KIRKLEES METROPOLITAN COUNCIL INVESTMENT & REGENERATION SERVICE

DELEGATED DECISION TO DETERMINE PLANNING APPLICATIONS

Reference No:	2025/62/92372/E
Site Address:	78, Marsh Lane, Shepley, Huddersfield, HD8 8AP
Description:	Erection of single storey side extension and associated alterations
Recommending Officer:	Kirsty Nicholls

Officer Report – 2025/92372

General Arrangement as Proposed

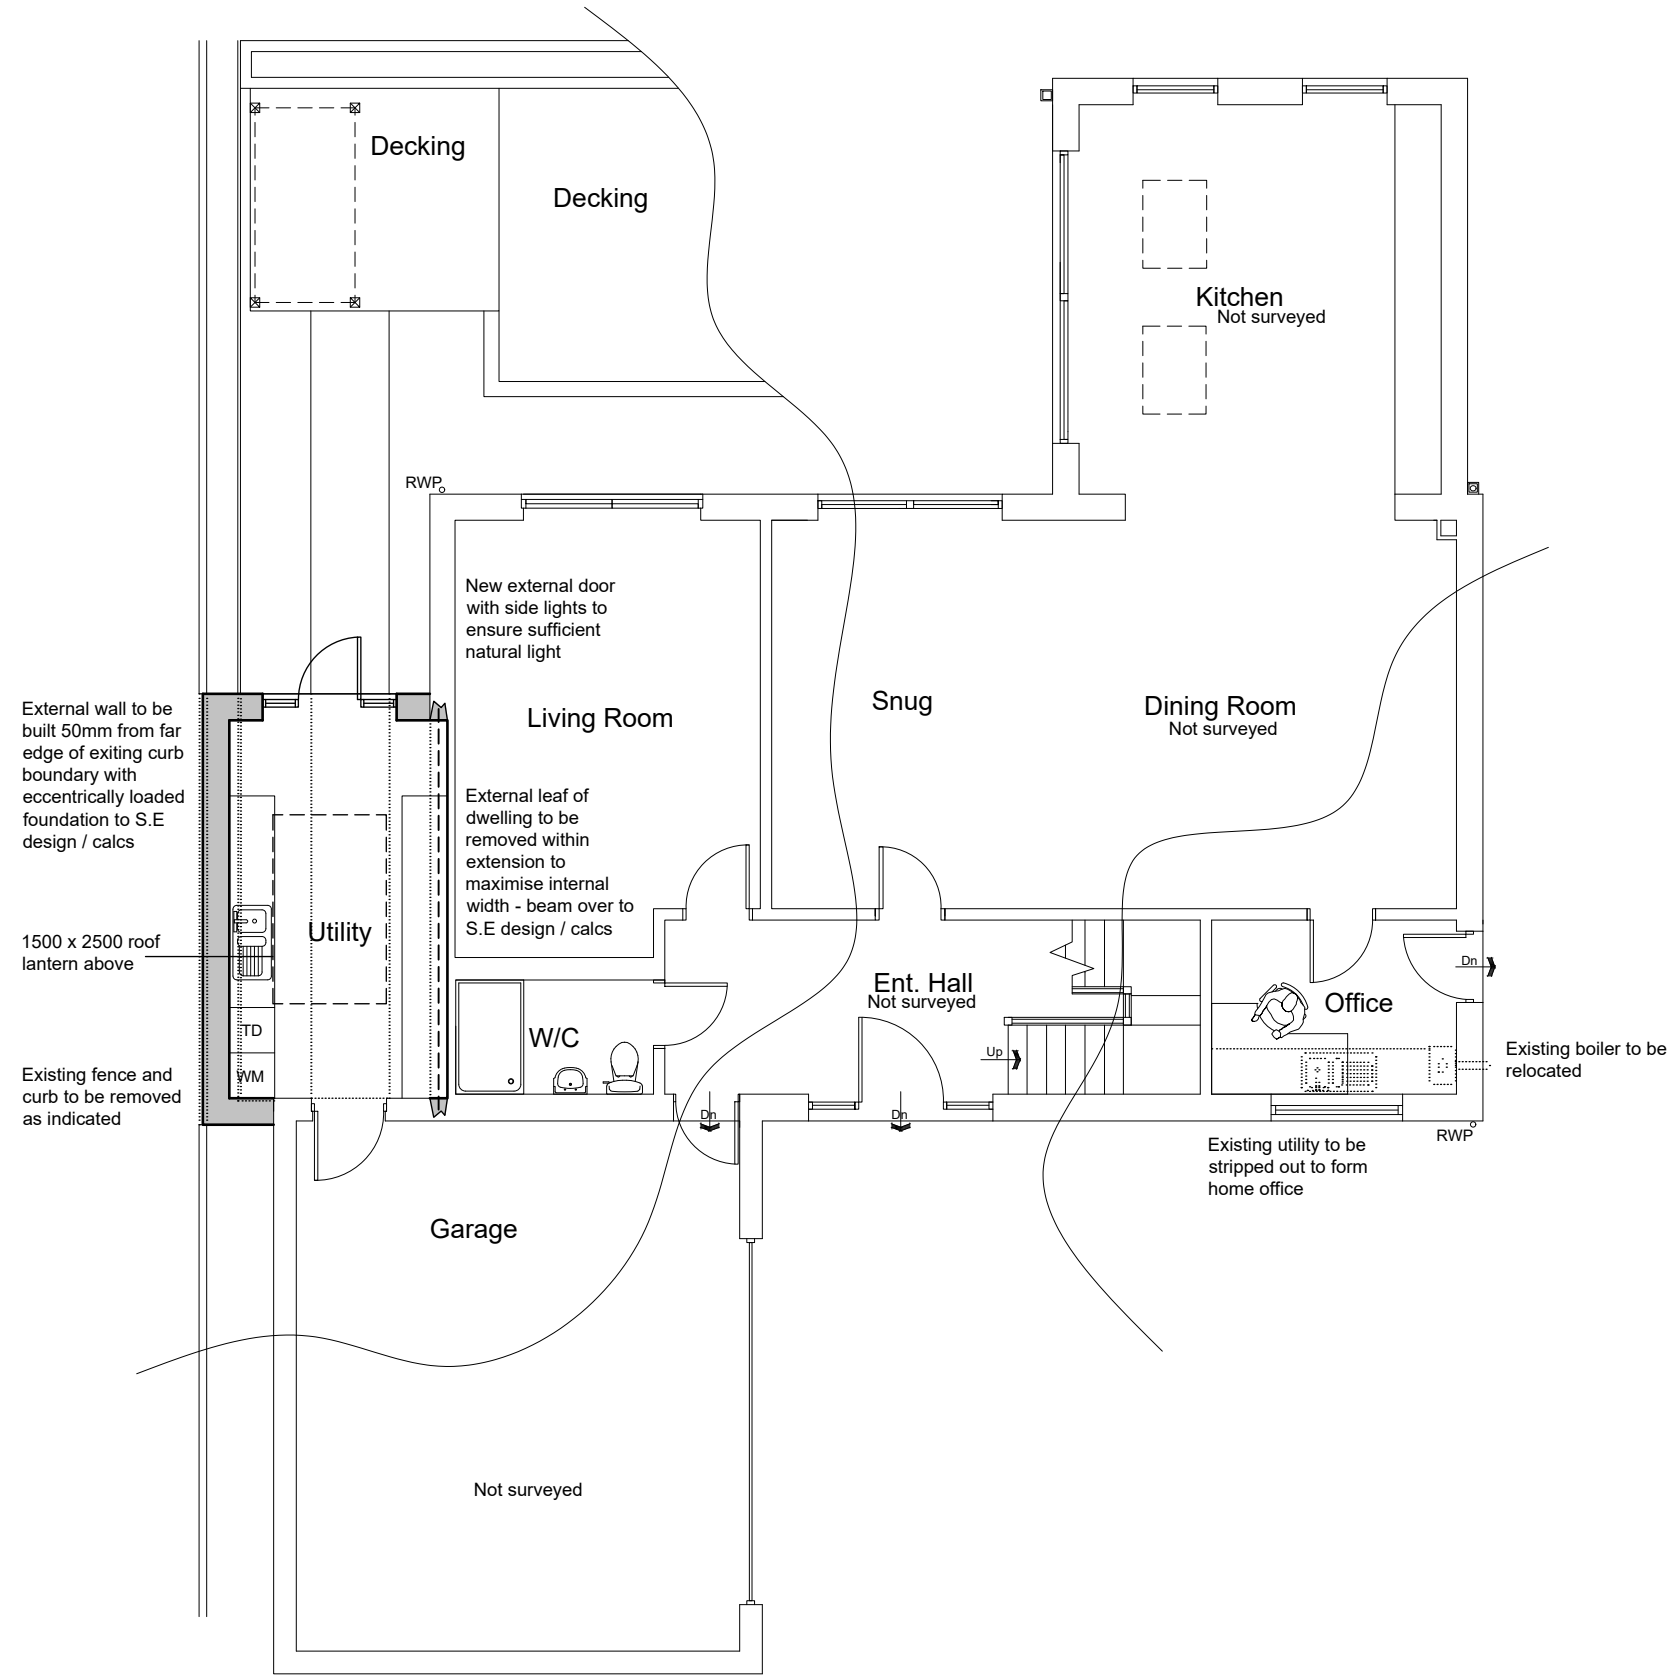
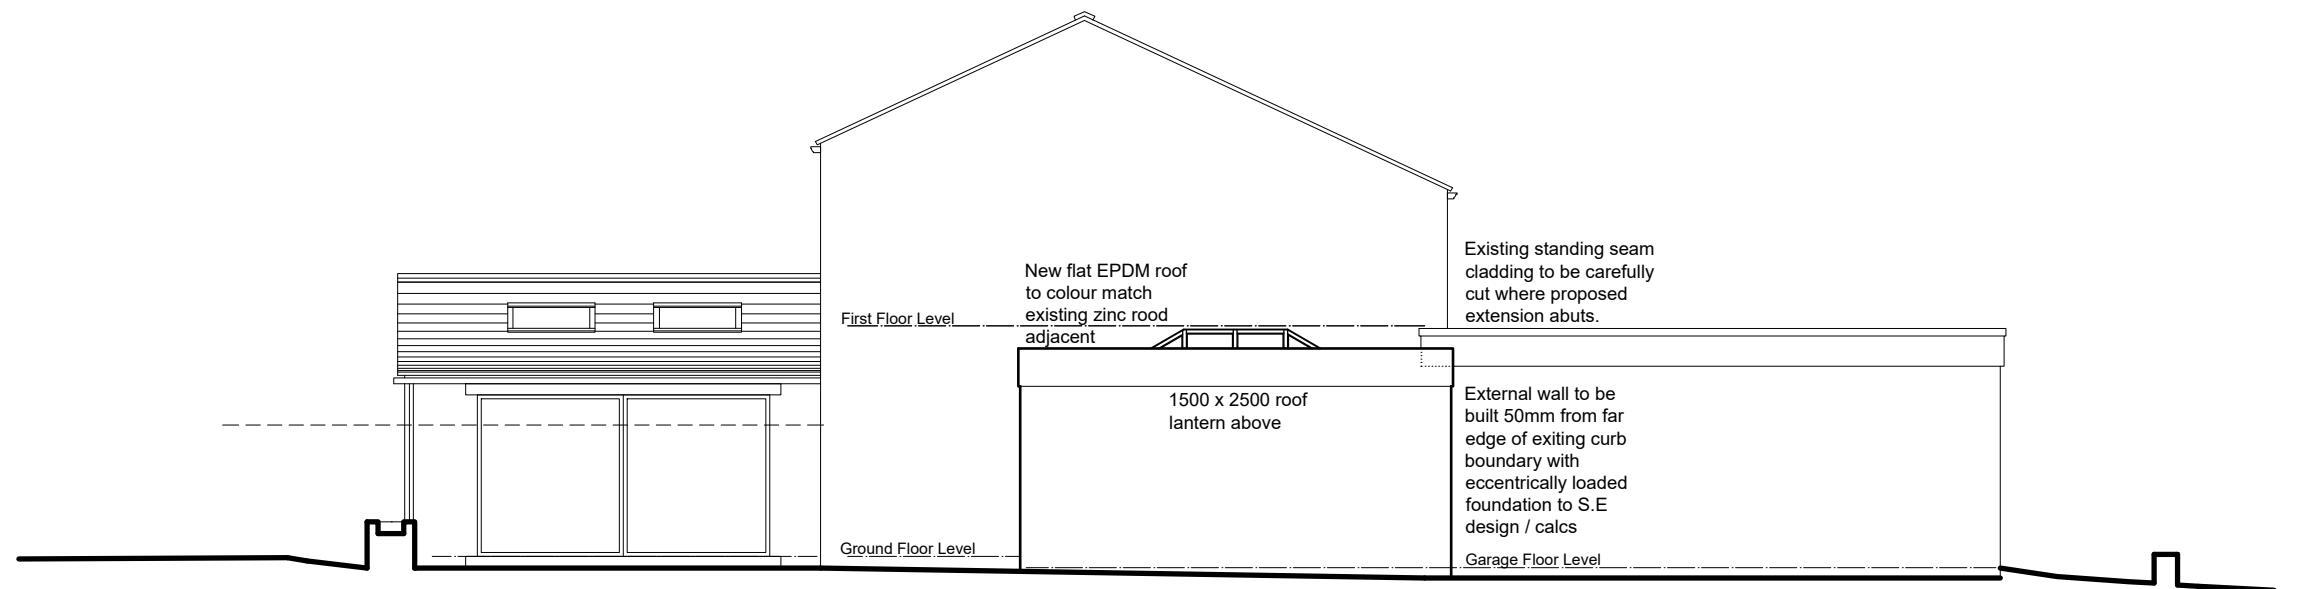
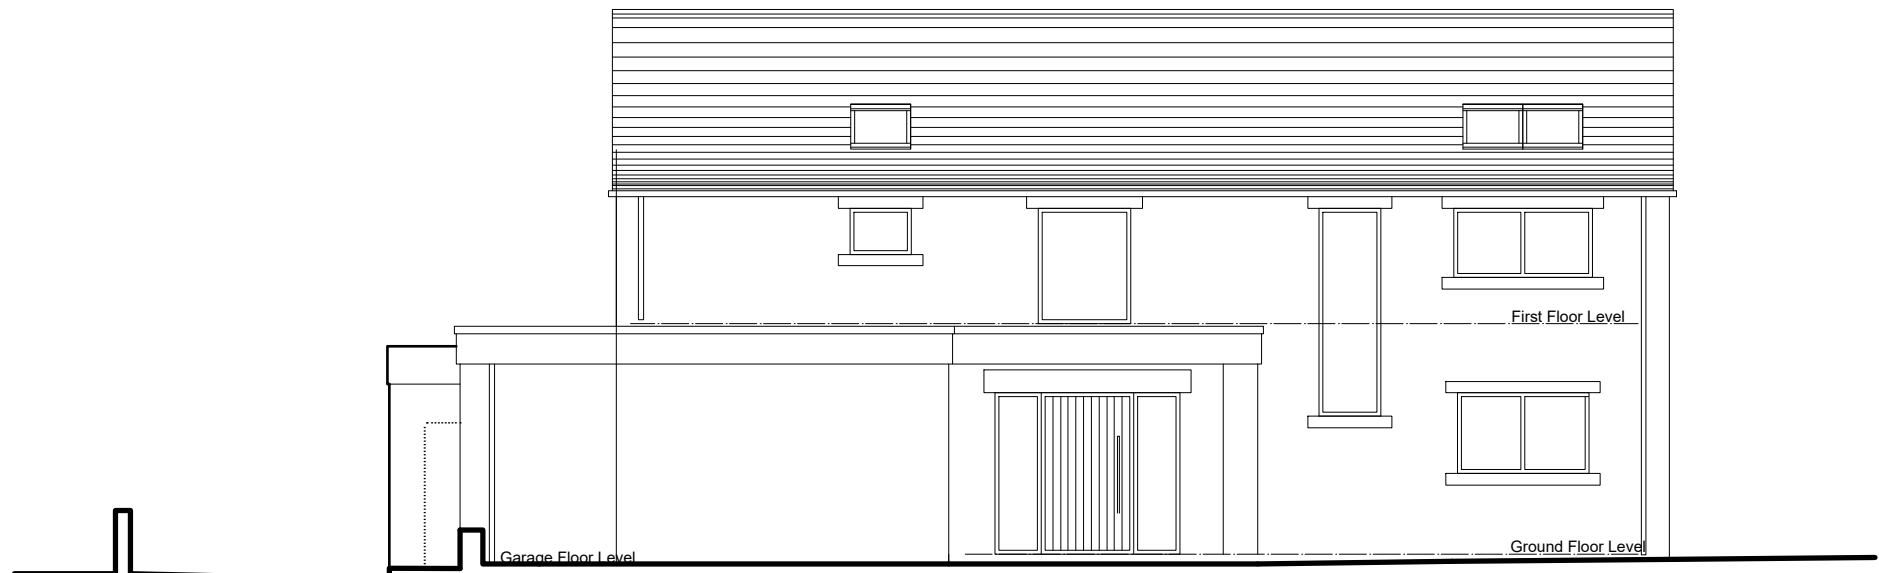
The proposed single storey side extension is considered to be designed to limit the impact on the local character of the area, reflecting the design of the original building by using matching materials including coursed natural stone and powder coated aluminium doors and windows. Whilst the extension will be positioned on the boundary of the site, removing an area of the existing fence to facilitate it, in isolation, it is limited in scale and massing. The site boundary where the extension will be positioned faces an existing footpath. It will extend the massing along the boundary as the extension will be positioned to the rear of the existing garage projection. However, the garage is set off from the site boundary which will mitigate any significant harm.

Whilst the use of a flat roof is not usually a design feature that is supported, in this instance, the design concept of the property is contemporary with flat roof structures being present. Furthermore, the installation of the roof lantern will further act to mitigate any significant harm in this instance.

As the extension is set away from any neighbouring properties, it is considered that there will be no impacts on light into neighbouring habitable rooms, or any potential overlooking into neighbouring properties as there are no windows in the side elevation of the extension, and the windows in the rear elevations are an adequate distance away from neighbours to have no extra impact than existing windows in the front and rear elevations of the application dwelling.

Whilst the extension will be positioned on the boundary of the site, removing an area of the existing fence to facilitate it, in isolation, it is limited in scale and massing. The site boundary where the extension will be positioned faces an existing footpath. It will extend the massing along the boundary as the extension will be positioned to the rear of the existing garage projection. However, the garage is set off from the site boundary which will mitigate any significant harm.

- The original structure sat at a distance to the communal boundaries. The proposed structure pushes the limits to the boundary, with the resultant bulk creating an oppressive feel on the adjacent path. – **Officer Comment** – *This is addressed in the sections ‘Impact on Character and Appearance of the Area’ and ‘Impact on Residential Amenity’ of the above report.*
- The original building was permitted with the ‘breathing space’ to the boundaries with this proposal contrary to this. – **Officer Comment** – *All applications have to be assessed on their individual merits and whilst the original permission had a set off from the boundary, it is considered that the proposed extension will not significantly impact on the parameters agreed at that stage.*
